CITY OF ALBUQUERQUE

**Re: Boulders Phase II
 Release of Financial Guarantee—Not Accepted,
 Stamp Dated 11/19/2013
 Engineer's Stamp Date 10/24/2012 (B11/D001C)**

| LEGEND |                         |

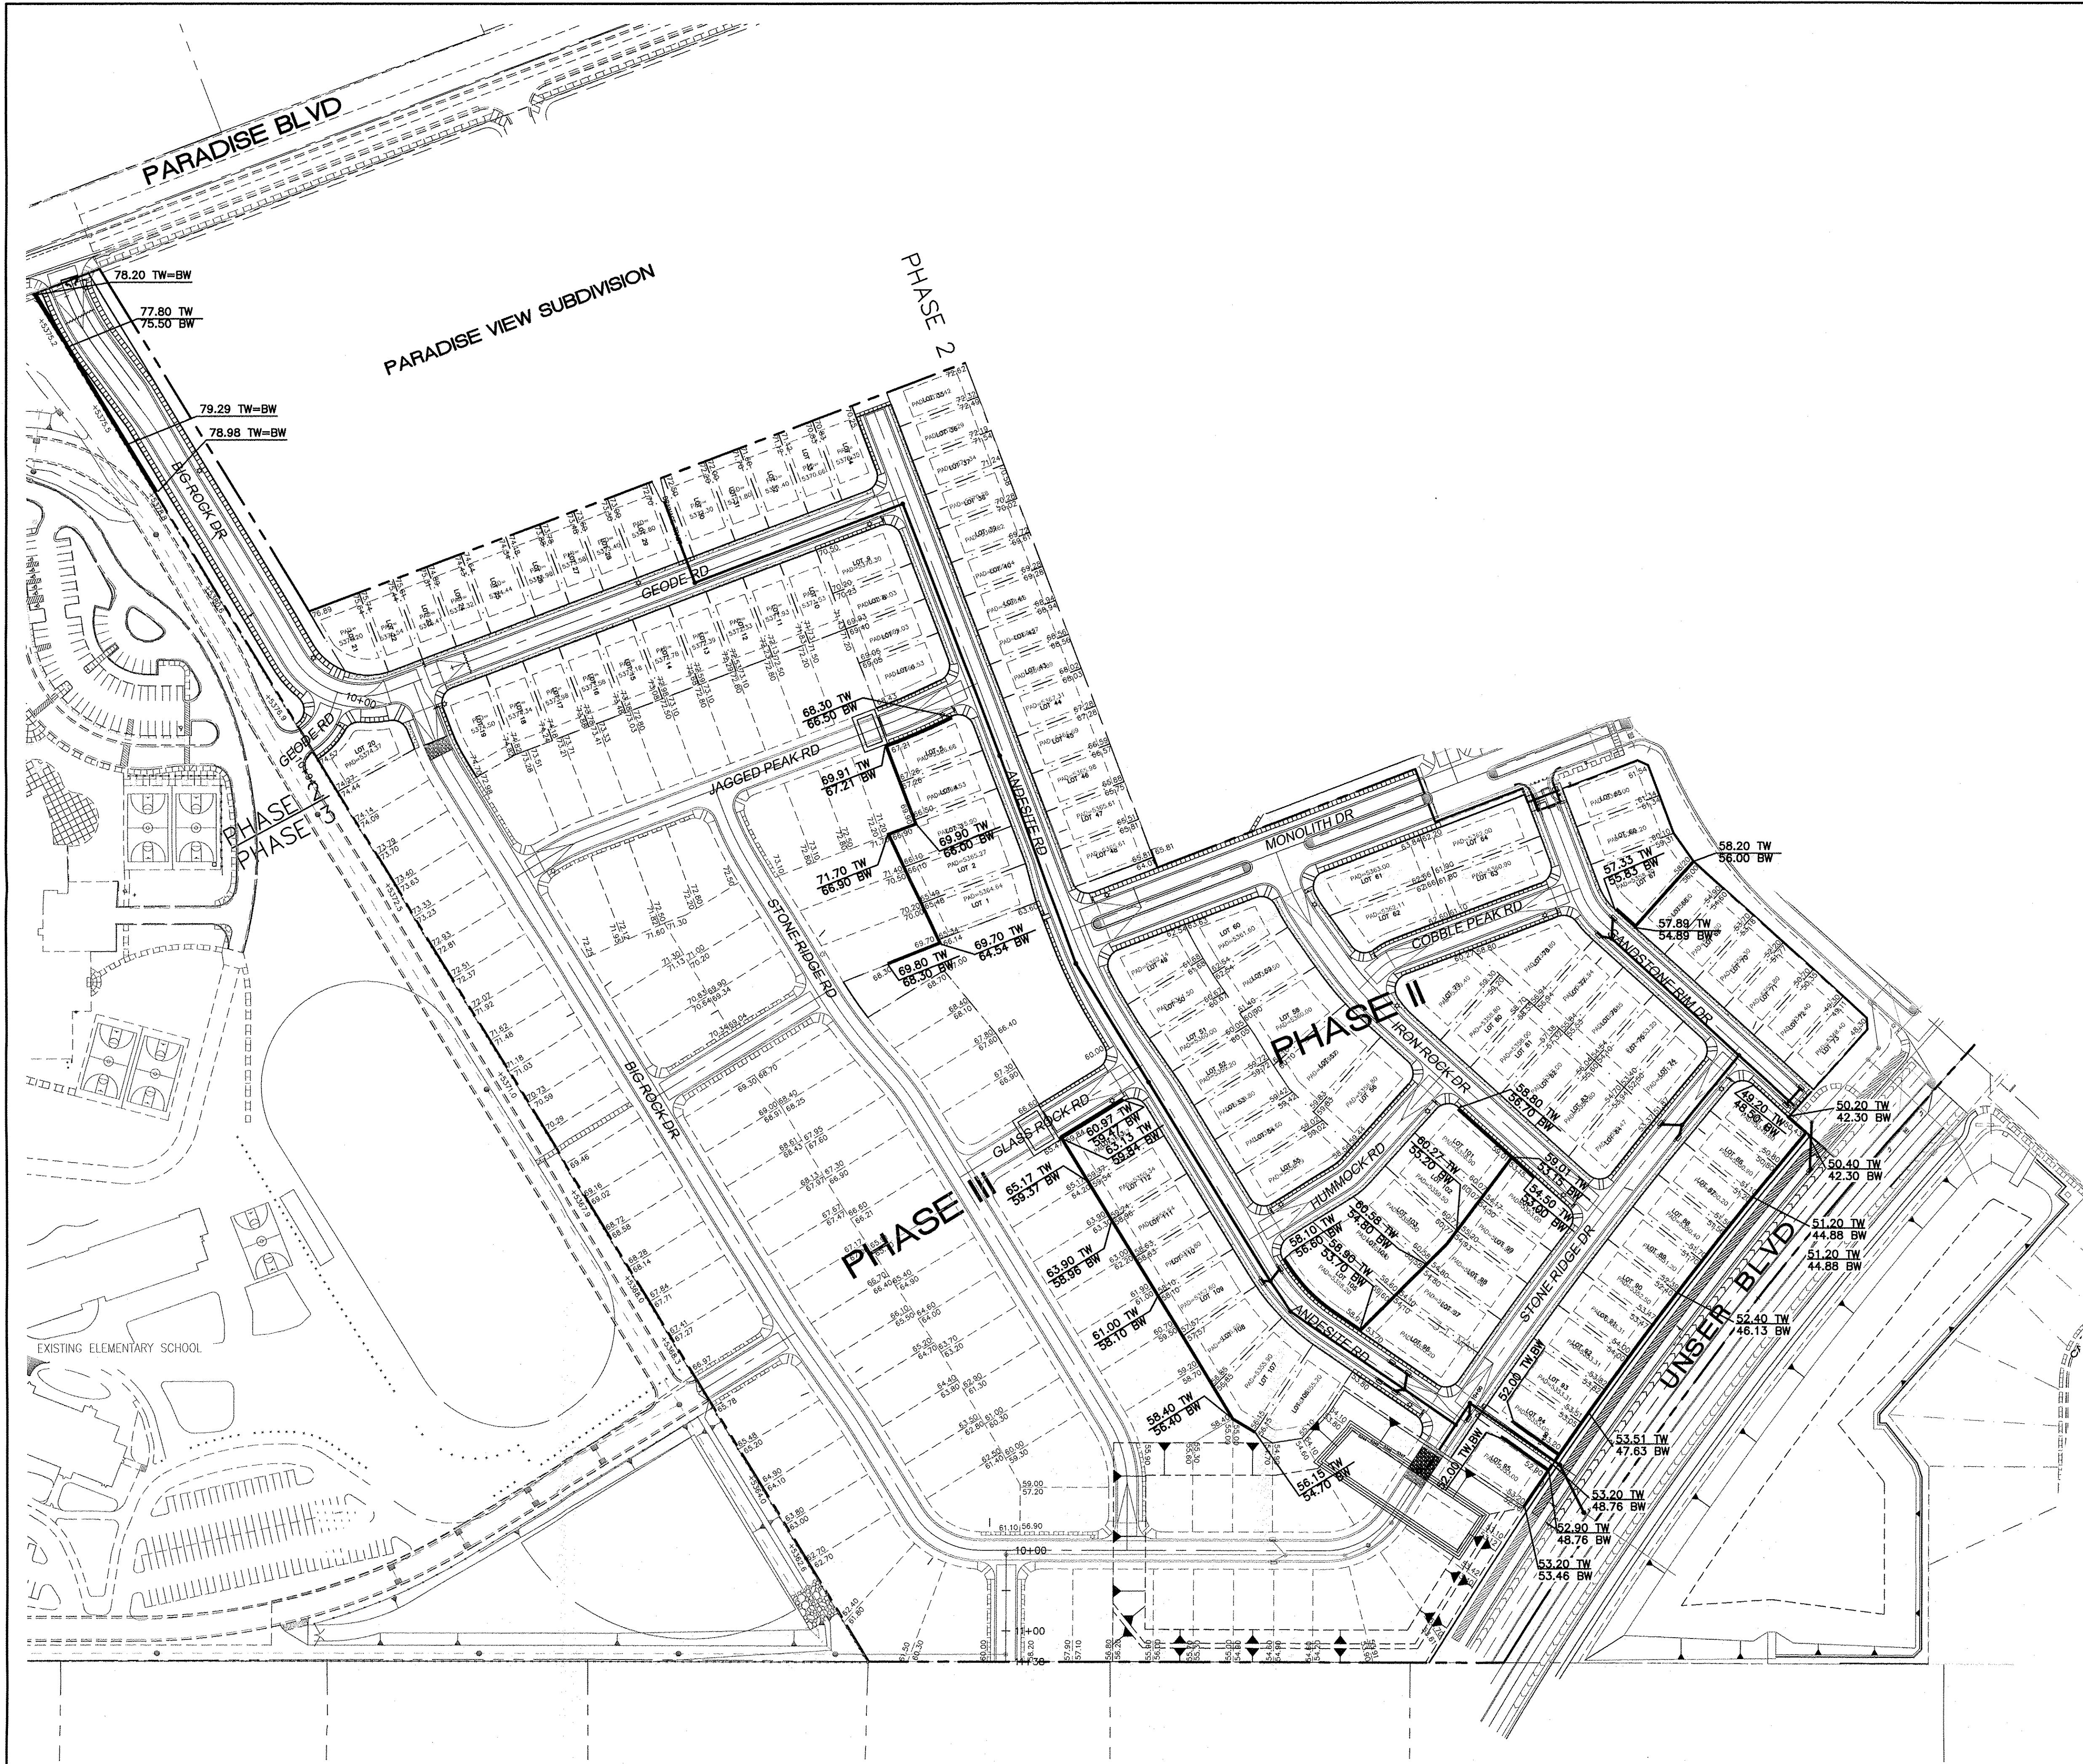
Please provide the pad grades on the DRB approved grading and drainage plan.
